Town & Country Planning Act 1990 (as amended)
Town & country Planning (Development Management Procedure) (England) Order 2015
Application for Planning Permission for Works or Extension to a Dwelling

Development Two storey rear extension, recessed second floor extension, swimming pool, landscape works, retention of two storey containers & hoarding.

Location La Casa 57 Coastal Road Kingston

1:100 North elevation as existing

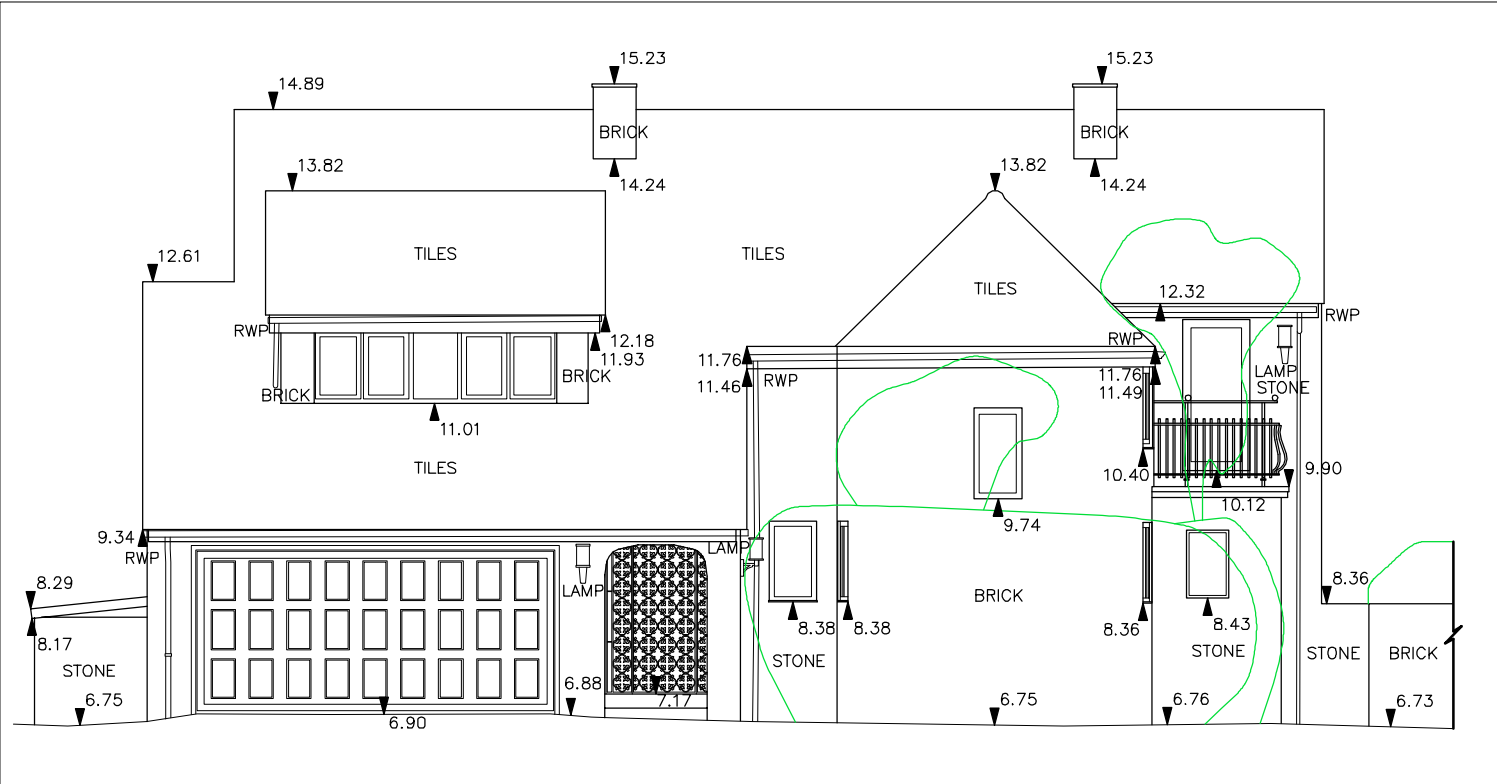
The existring ground and first floor plans and north elevation do not accord. Please amend accordingly.

Block Plan as proposed

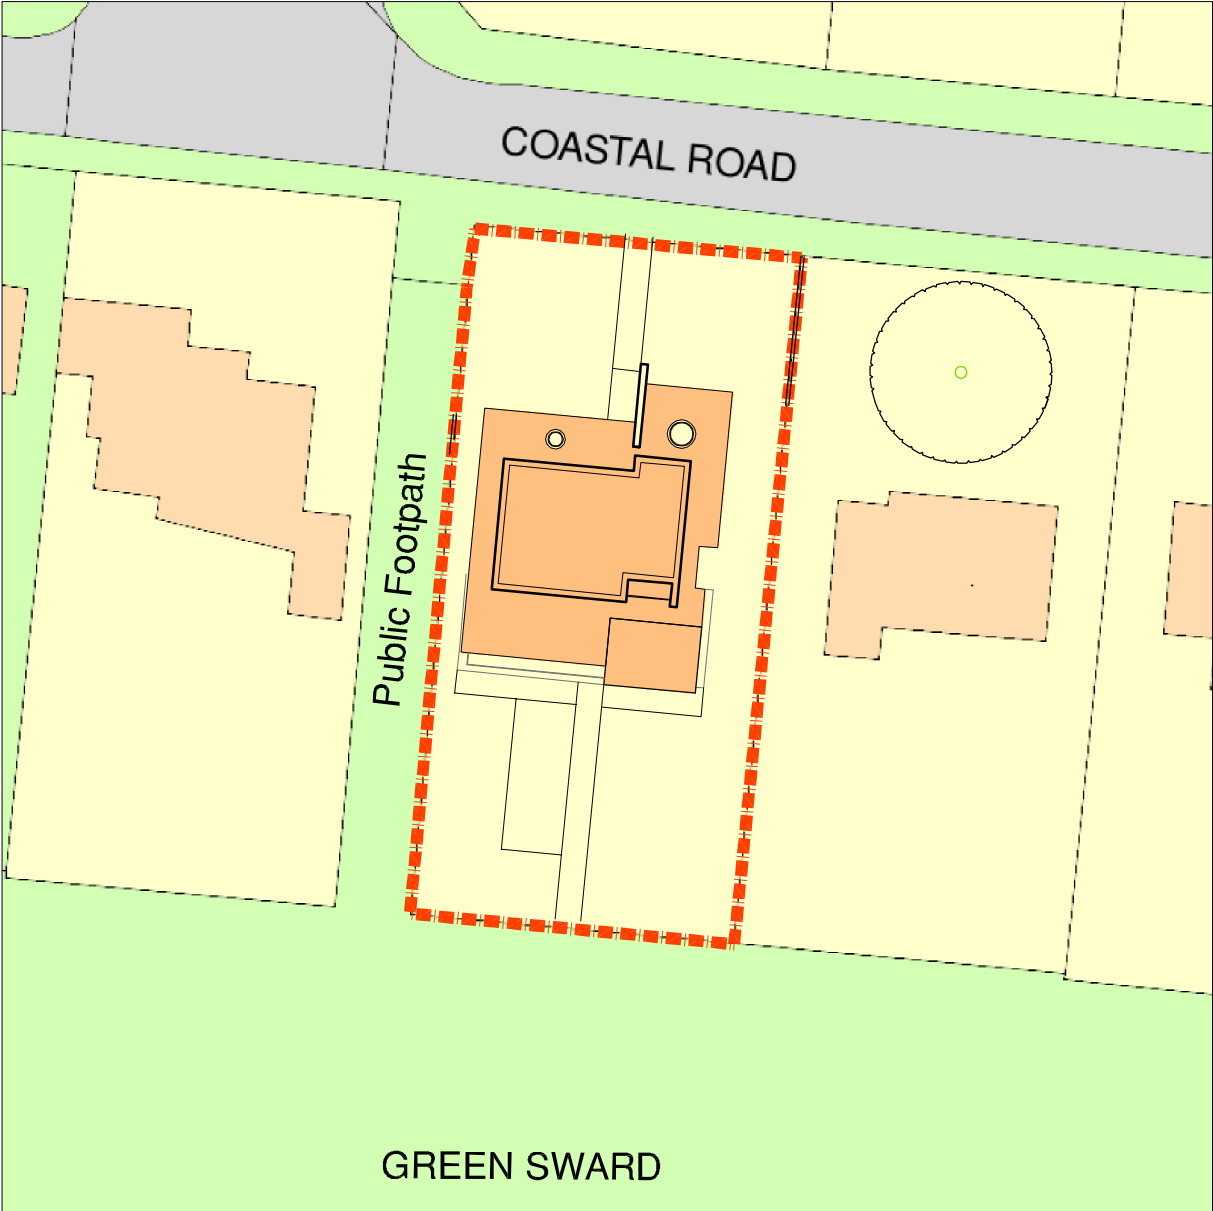
On the proposed block plan, please clearly highlight the proposed swimming pool.
